From: Amanda Scholes on behalf of Planning.Responses
Sent: 08 March 2018 07:52
To: Planning Scanning
Subject: FW: Planning ref: A/8/18/PL FAO Mrs A Gardner
Attachments: planning objection ref a.8.18.pl.docx

Please find attached my objection letter to the planning application A/8/18/PL on the land to the rear of 1
- 6 The Cottrells.

I am writing in objection to application A/8/18/PL for the land behind 1 – 6 The Cottrells.

Ground Floor Plan @ 1:100

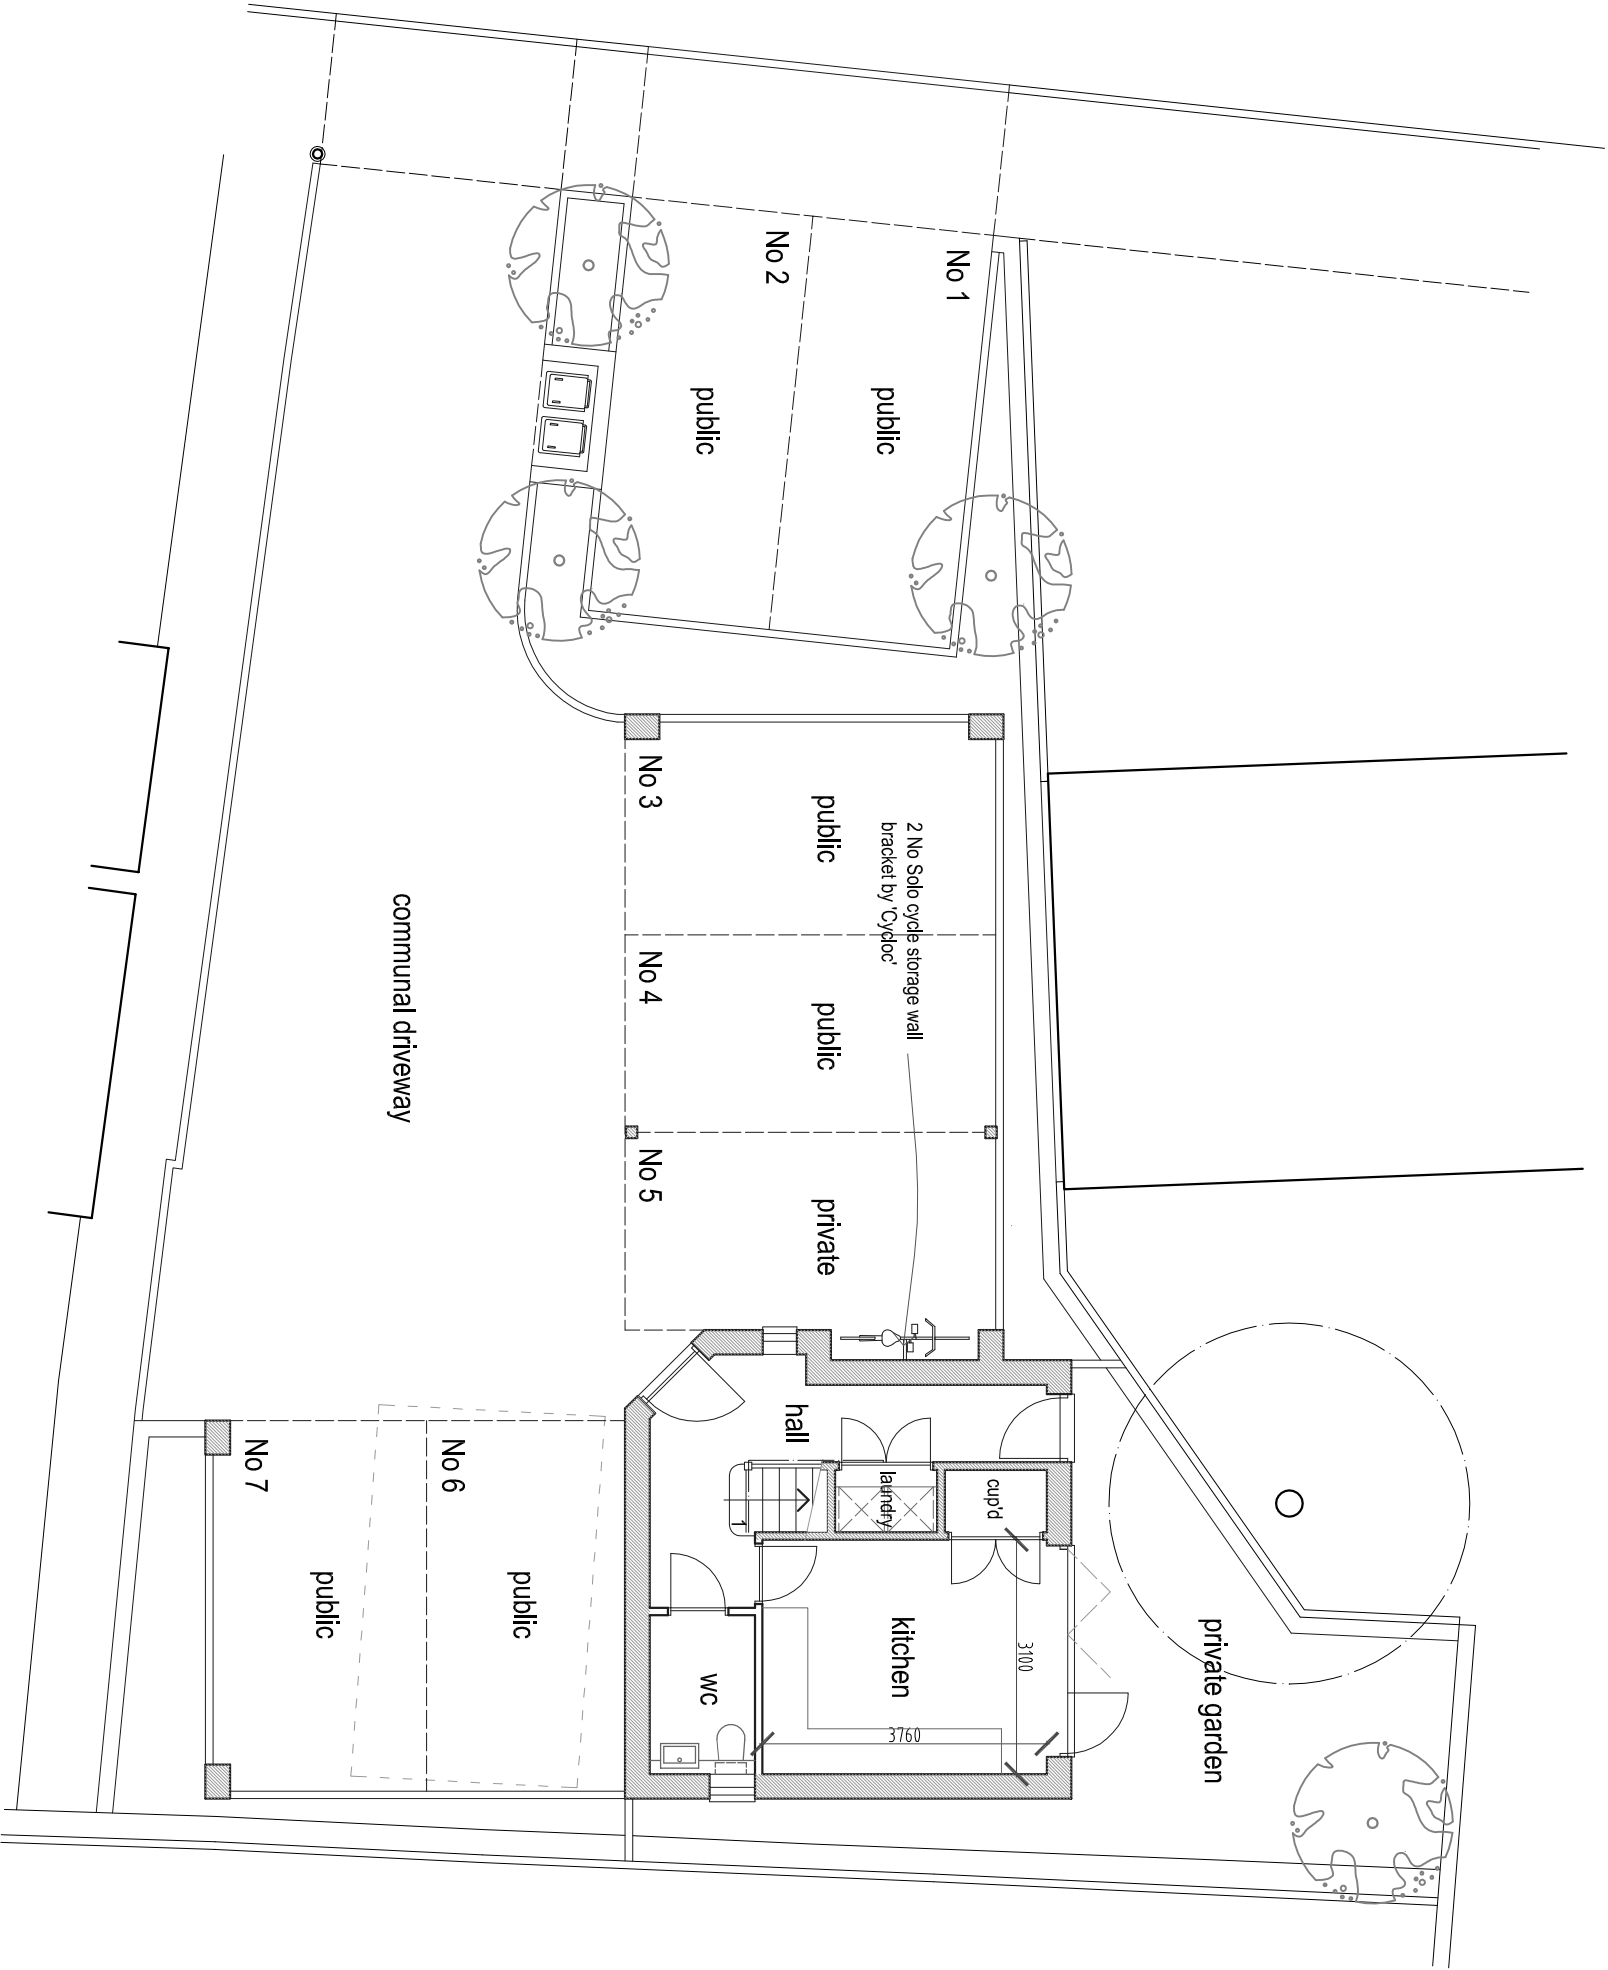
The original approved plans are for a 2 bedroom property, with revisions for a 3 bedroom turned down. The addition of a hallway downstairs, and the knowledge that all of the services have been put in place upstairs to move the kitchen after the building has been signed off, leads me to believe the developers are planning on reinstating the third bedroom that was dismissed. A three bedroom home would undoubtedly need more than the one parking space allocated to the property and cause even more parking issues down and already congested road. I would request that the internal layout be subject to planning controls to prevent this happening at a later date.

Another point to consider is that the plans now show brick posts in the car port as opposed to the timber posts in the approved plans. Which is it to be? Perhaps the conservation officer should take some interest and ensure that the posts used are the ones that best fit the area and not whatever the developer decides is easiest and cheapest?

Rev	Description	Date
Job Reference New House The Cottrells Angmering, BN16 4AF		
Client AM Homes Ltd		
Drawing Title First Floor Plan & Roof Plan		Drawing No ADC962/13
Date 16.01.18	Scale 1:100	Dwg Size A3
		Plot Style ADgrey.spl
		Drawn AD
		Checked AD

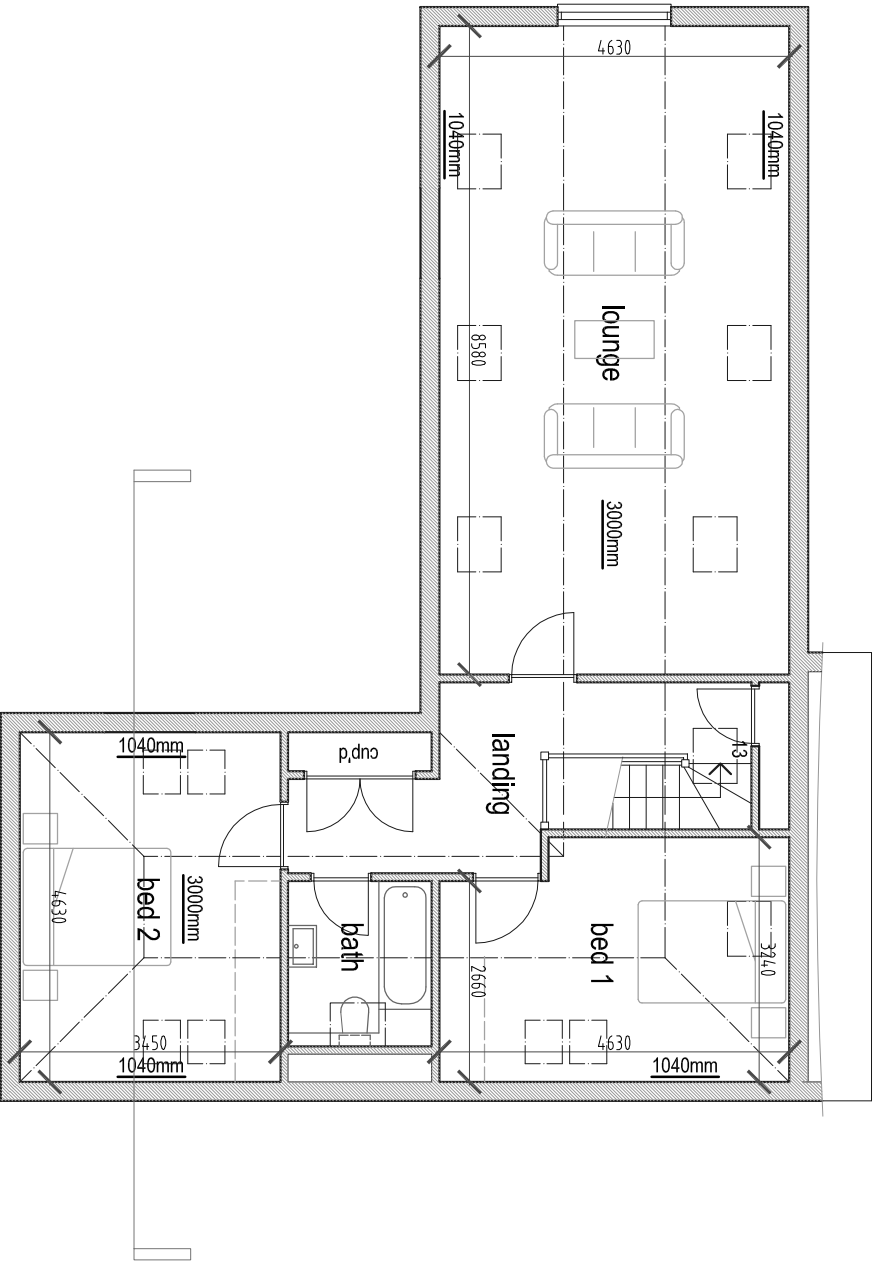
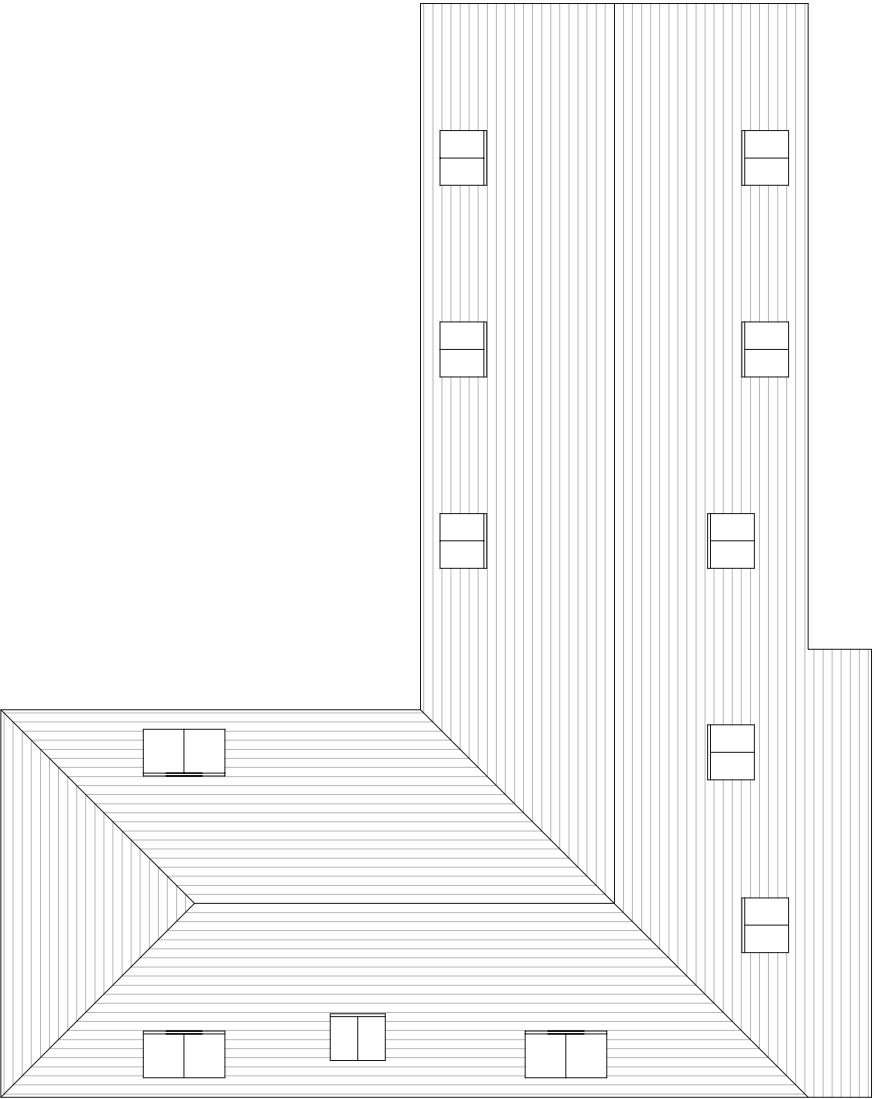
The developer has built a building with a completely different roof elevation and pitch to those approved. The approved plans show a hip end on the roof facing the rear of 5 The Cottrells, however a barn end is what has been built. This gives an overbearing presence to the property, blocks light to the surrounding gardens and doesn't fit in with the local houses. This barn end has been installed with the aim of increasing the internal space available and benefits The Cottrells or the conservation area in no way. The pitch of the roof is much higher and steeper than the original plans, again to the benefit of the developers and the detriment of the road, resulting in a much larger and more imposing building than the homes surrounding. I would also like to add that the new plans of the elevation show two different types of roof facing 5 The Cottrells. The front (west) elevation shows a hip end; the side (south) elevation shows a barn end. What exactly are they planning on doing with this?

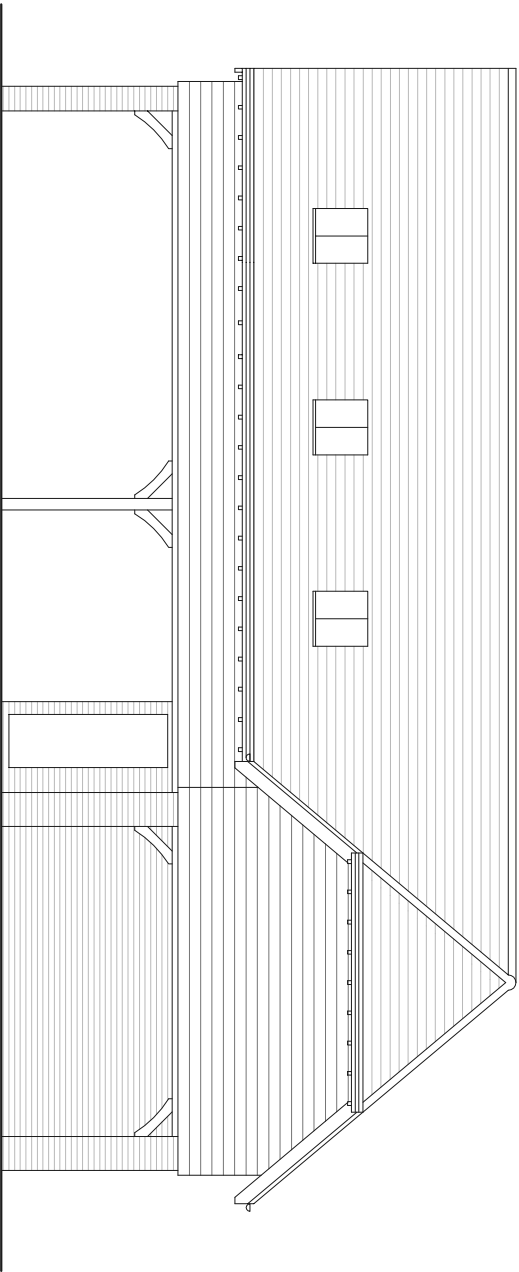
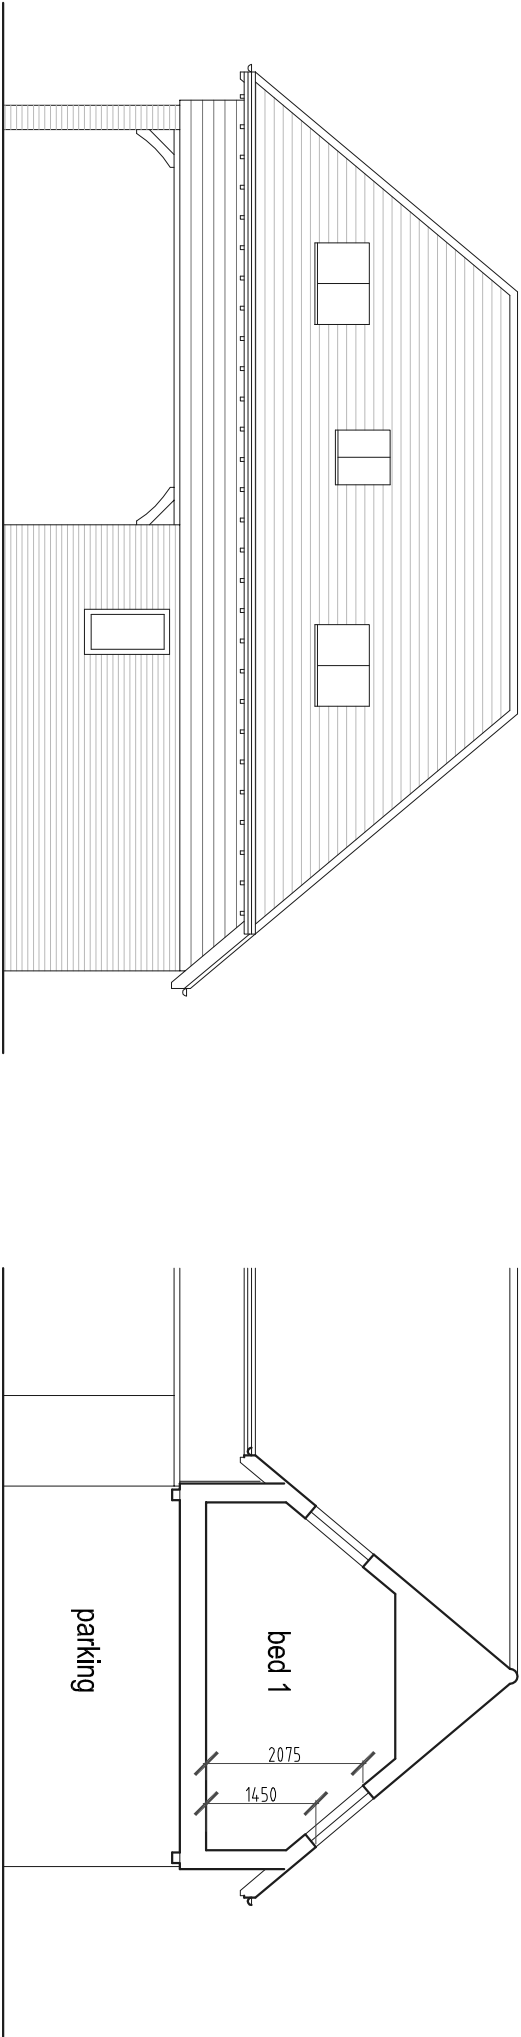
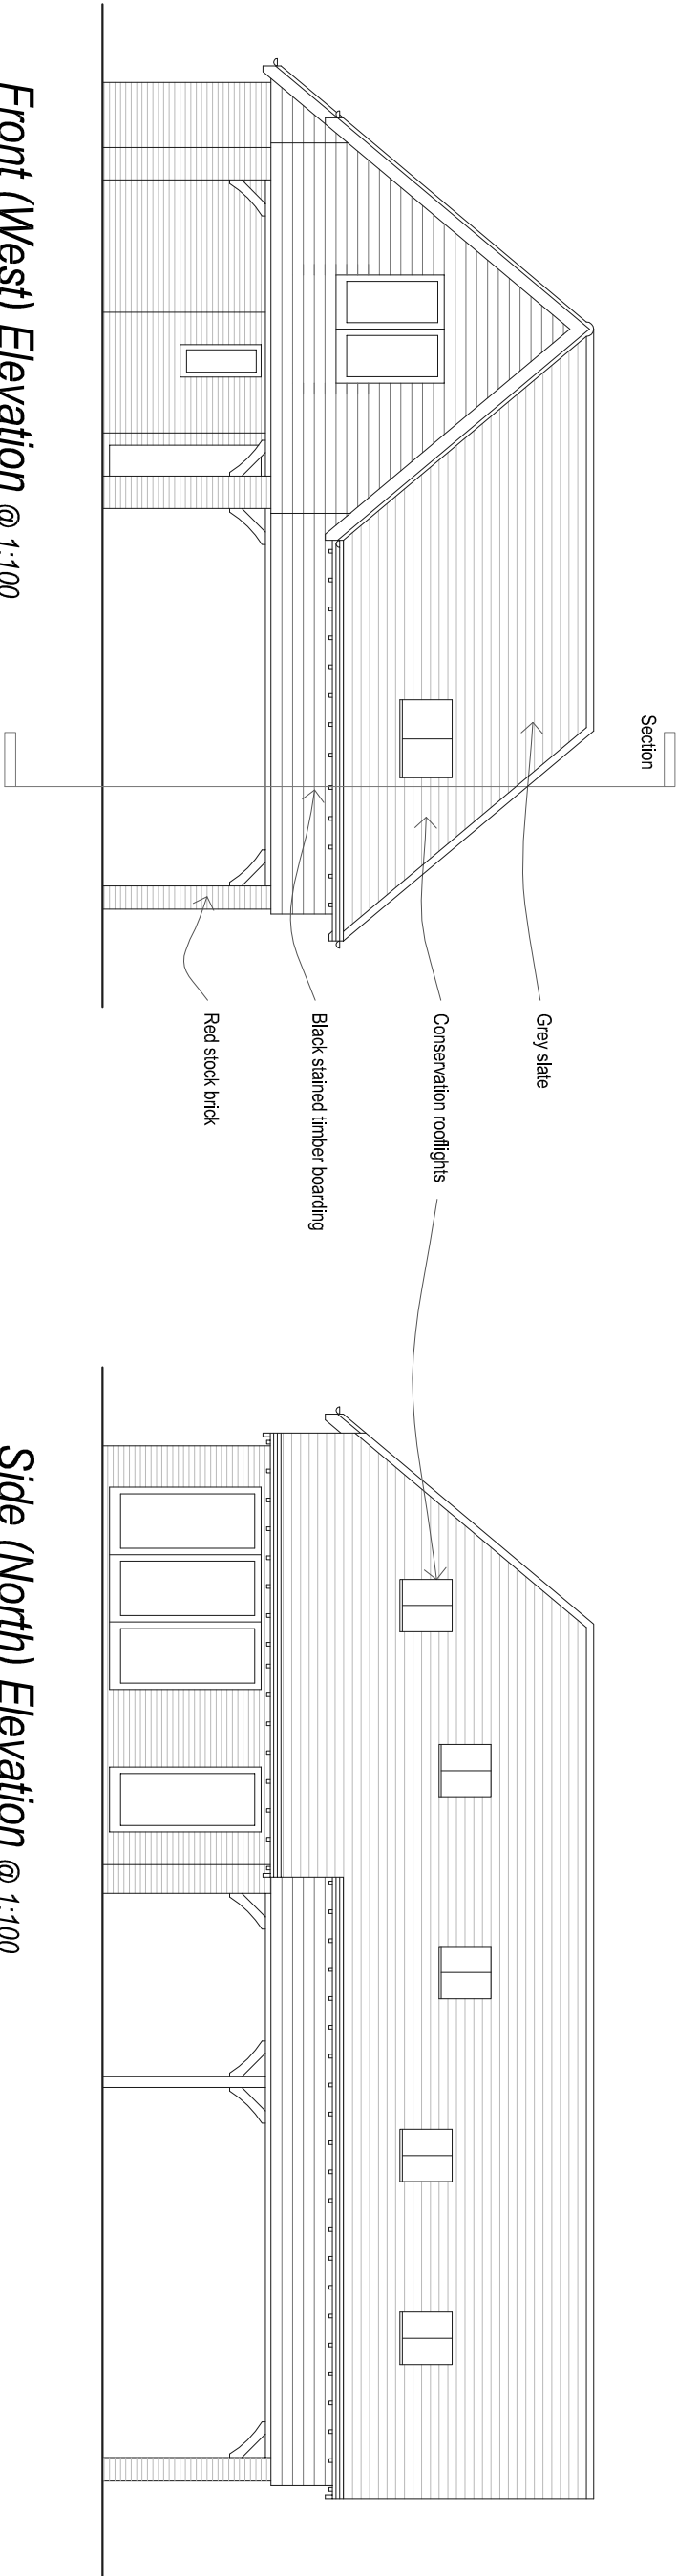
The rooflights that have been put in place are at a different height and of a different type to the ones shown in the approved plans. The windows that have been installed appear to be ordinary Velux and not the escape heritage rooflights that were passed in planning. The lowered heights of the windows mean they look straight into the rear bedrooms of 1 – 6 The Cottrells and greatly affects our privacy. We now keep the blinds shut permanently to prevent our privacy being invaded and do not look forward to being able to watch our future neighbour as they sit in their living room. This objection is as much for the future resident's privacy as ours. Has the development been

granted special permission to put the rooflights at a lower height or is this another modification the developer has seen fit to put in?
